Development Facilitation Team (DFT) – Review Comments

DRB Project No: PR-2022-007100 Date: 03/22/2023 Agenda Item: #3 Zone Atlas Page: B-14

Legal Description: [TRACT MM-1B TRACTS MM-1-A & MM-1-B, SEVEN BAR RANCH]

Application For: SD-2023-00038- PRELIMINARY PLAT (DHO)

Plat of
Tracts MM-1-B-1 and MM-1-B-2
Seven-Bar Ranch
 Town of Alameda Grant, Projected Section 8,
 Township 11 North, Range 3 East, N.M.P.M.
 Albuquerque, Bernalillo County, New Mexico
 August 2022

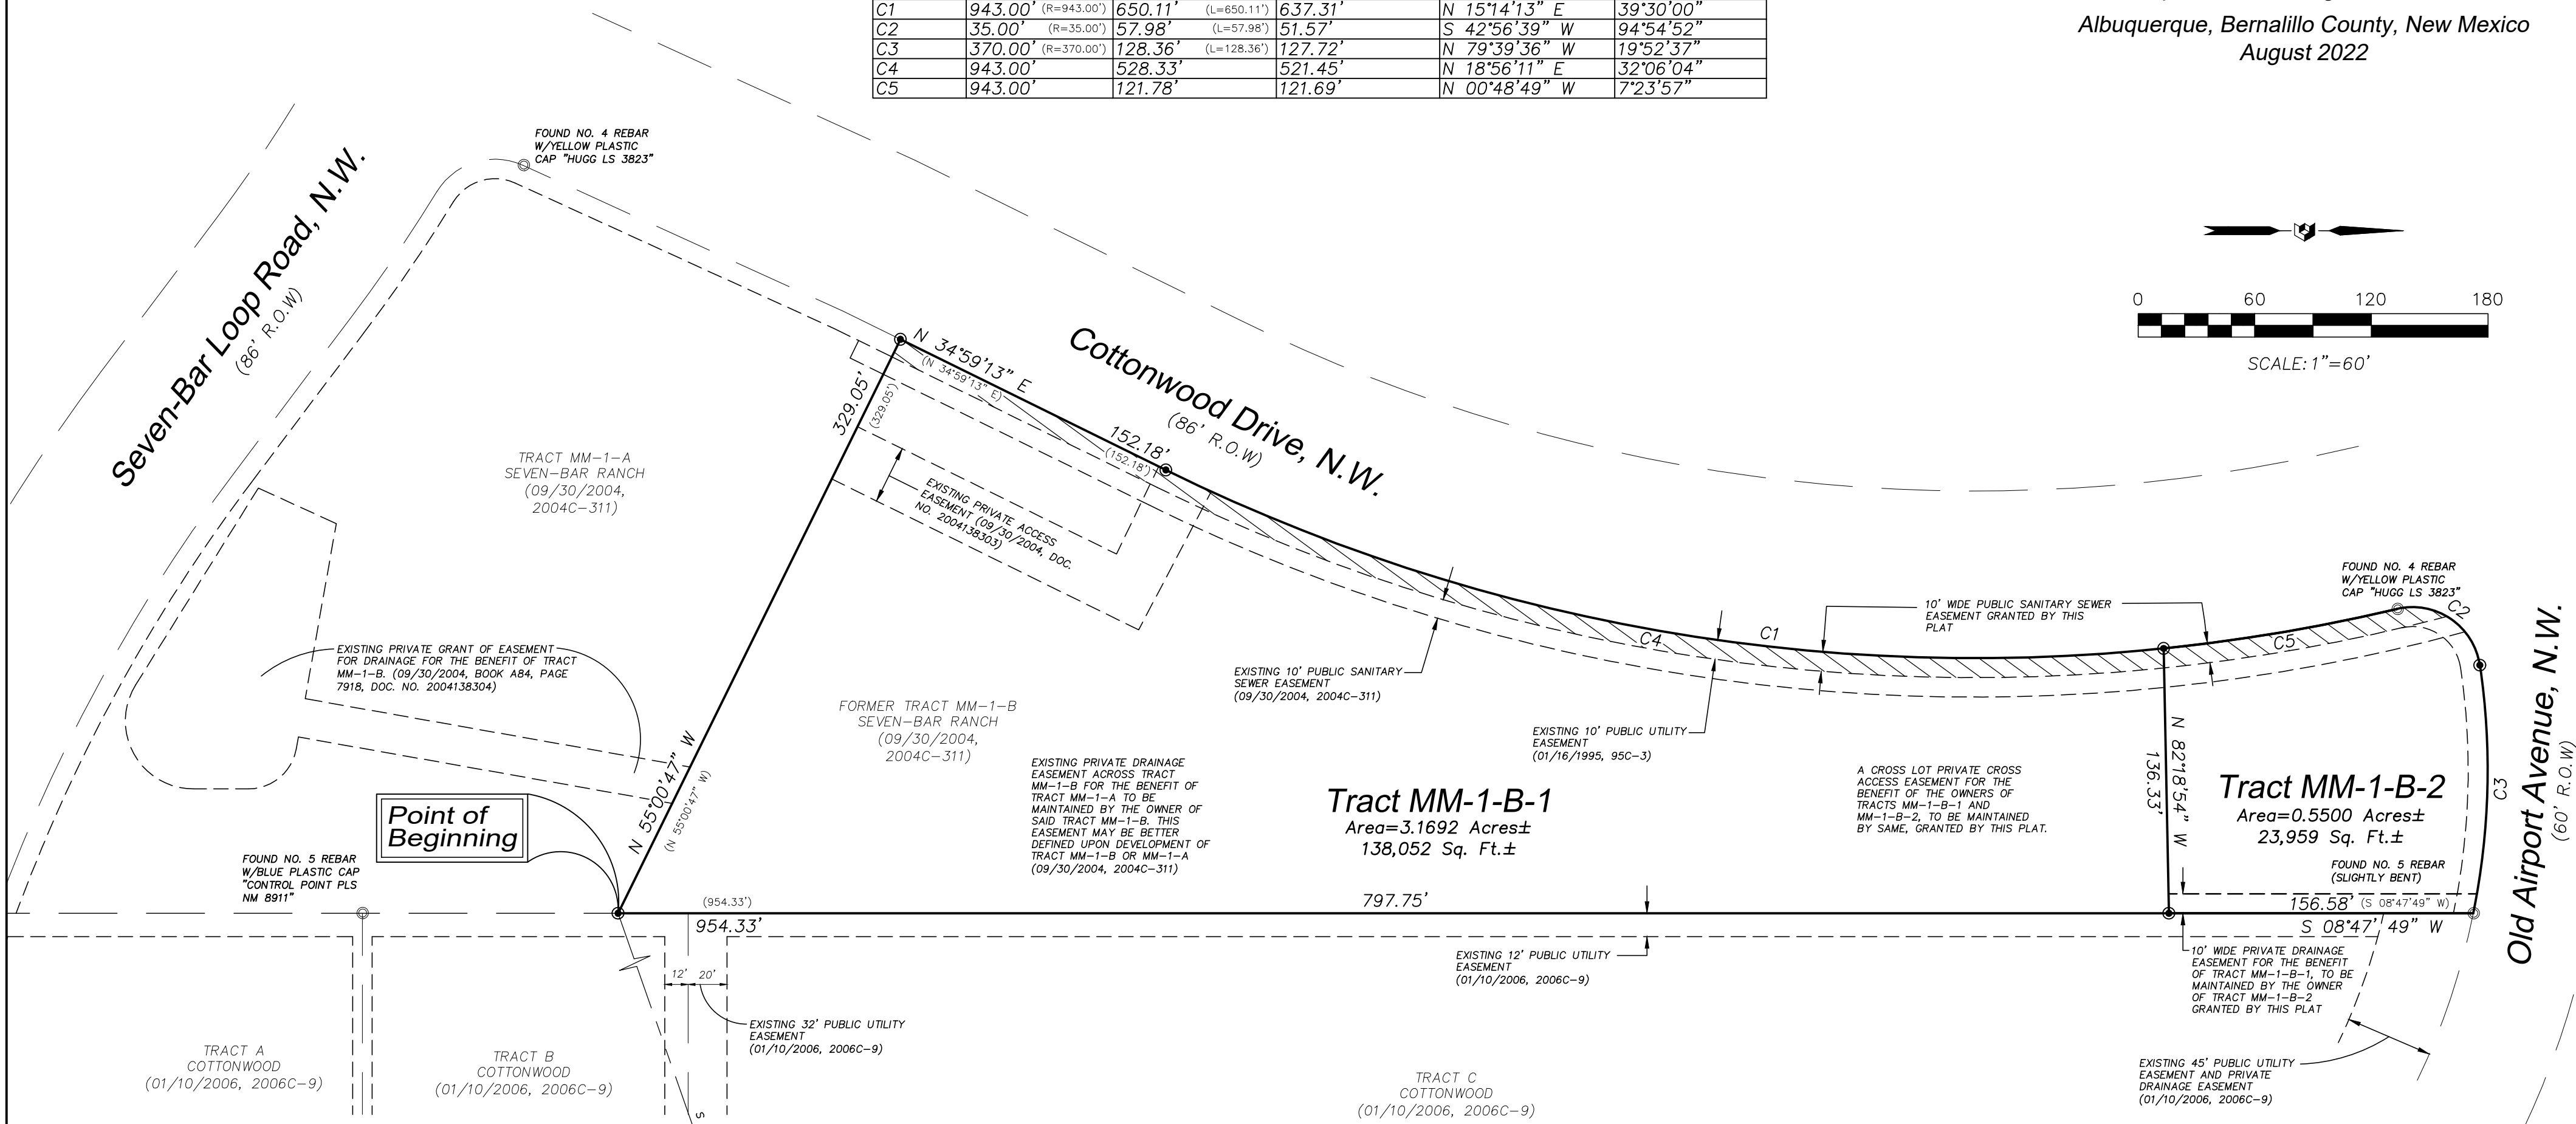
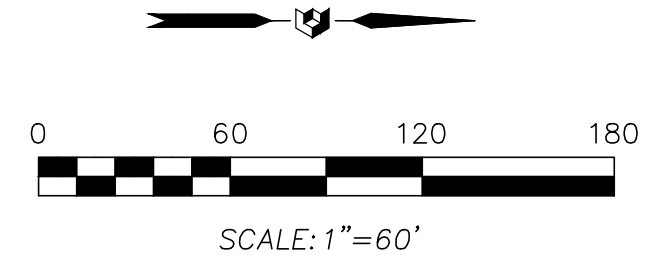
3. Infrastructure List (Updated)
 - a. Please state for size 8" SAS and not easement size.
4. Easement.
 - a. The minimum width easement requires is 20'. Please include a 20' easement for the public sanitary sewer line. (Exclusive)

- b. Please add the following note
 - i. ABCWUA Public Water & Sanitary Sewer Easements
Albuquerque Bernalillo County Water Utility Authority (ABCWUA) is granted easement(s) in the dimensions noted on this plat for the construction, installation, maintenance, repair, modification, replacement and operation of public water and sanitary service lines, equipment and facilities reasonably necessary to provide service together with free access on and over the easement and the right to remove trees, shrubs, undergrowth and any other obstacles, modifications, or structures which interfere with use of the easement.

FIIZ DRINKS ALBUQUERQUE, NM	DRAWN BY JL
	TREE EXHIBIT	DATE 3-17-2023
TIERRA WEST, LLC 5571 MIDWAY PARK PL NE ALBUQUERQUE, NEW MEXICO 87109 (505) 858-3100 www.tierrawestllc.com		DRAWING
		SHEET # T-1
AMANDA HERRERA P.E. #23575		JOB # 2022048

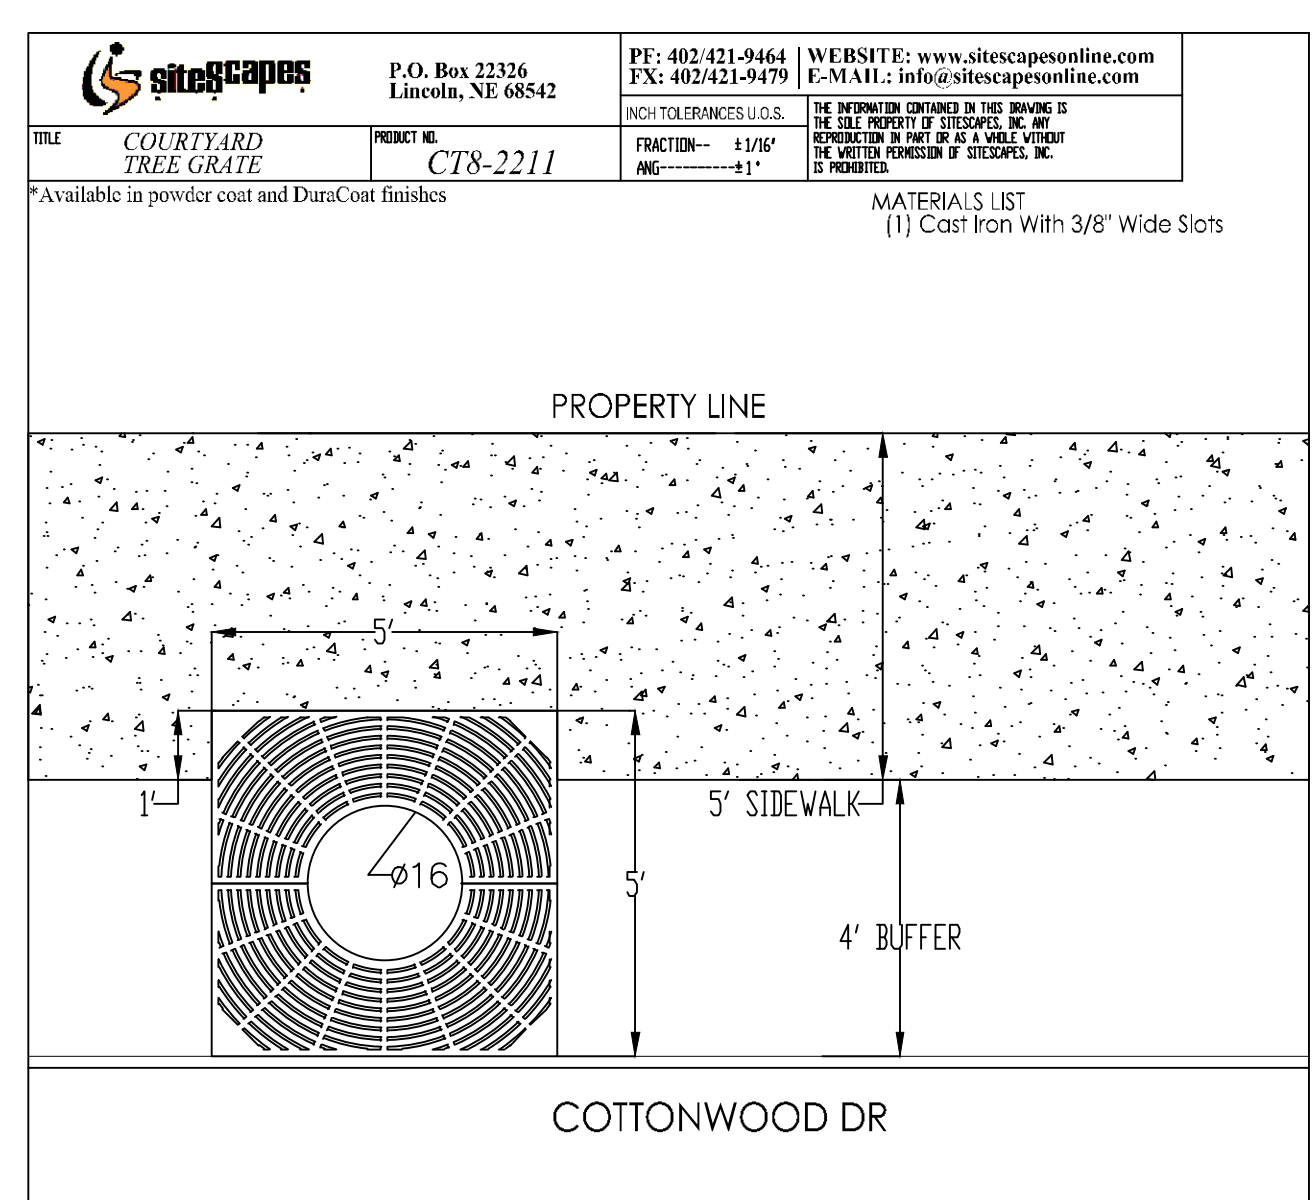
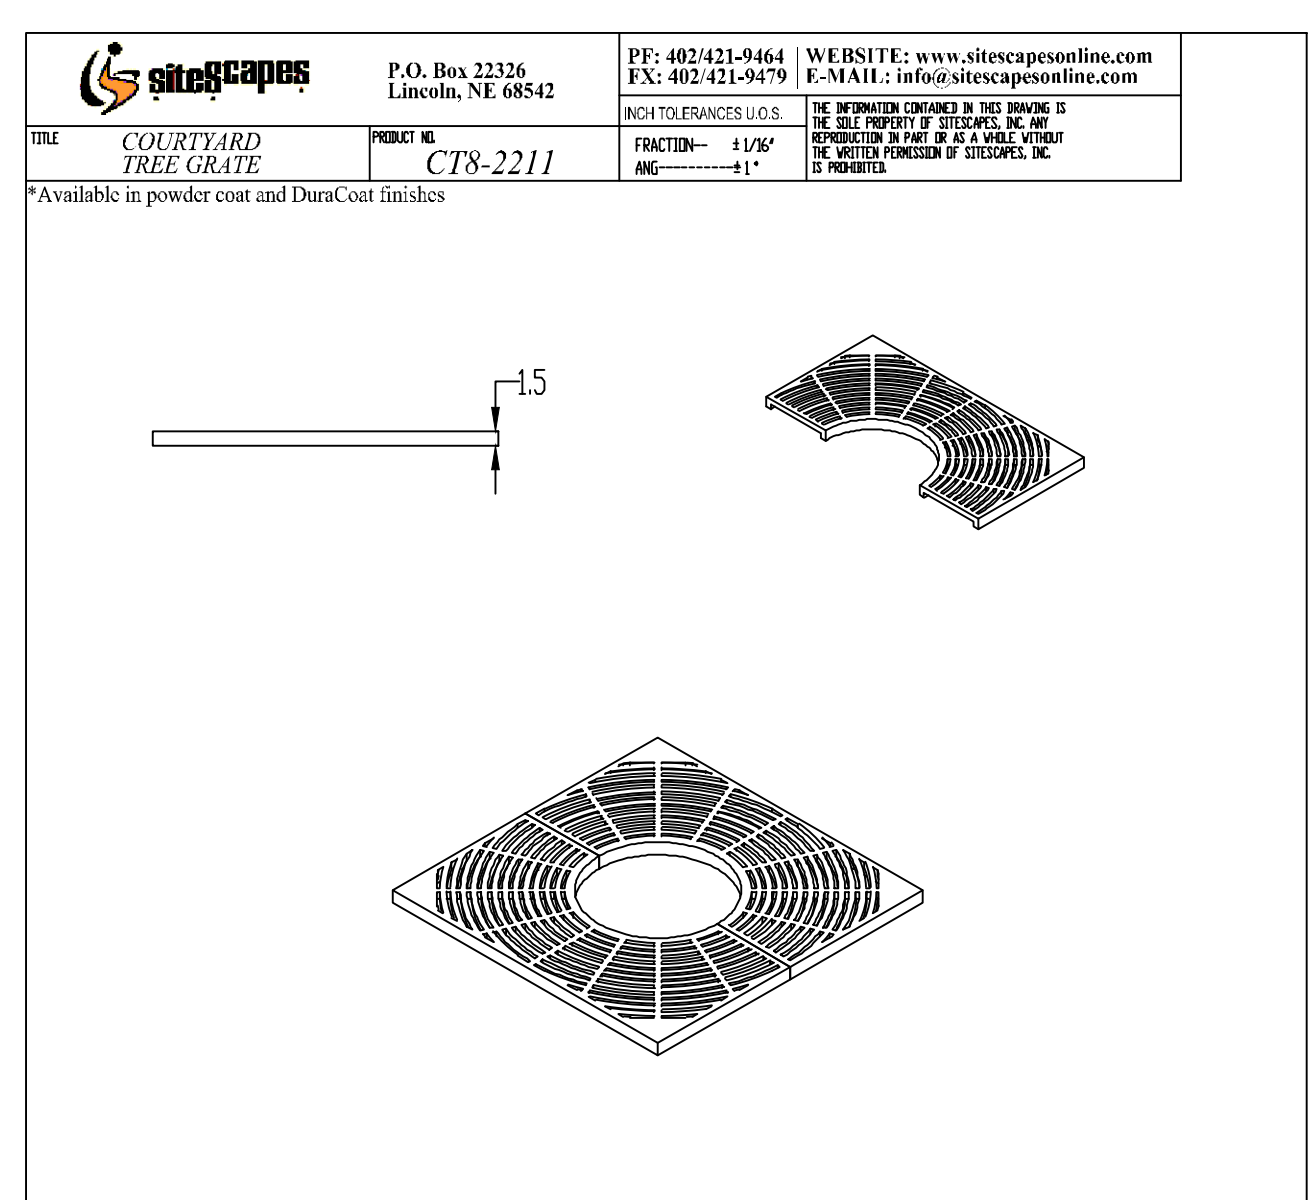
- The applicant completed a Sensitive Lands Analysis per IDO 5-2(C) and identified that no sensitive land features exist on the subject site.
- Compliance with section 7 of the DPM is required per Table 7.2.29.
Sidewalk width is 6 feet and a landscape buffer between the curb and the sidewalk should be 5-6 feet. Sidewalk is existing on Old Airport Road. Sidewalk needs to be built along Cottonwood Drive. Applicant team has proposed building a 6 foot sidewalk.
Updated 3.21.23: The Applicant is proposing a 4-foot landscape buffer expanding to 5 feet around trees; a 4-foot clear distance for ADA access would be maintained. The request is justified because of the two utility easements located on the inside of the sidewalk, preventing widening of the ROW for a landscape buffer.
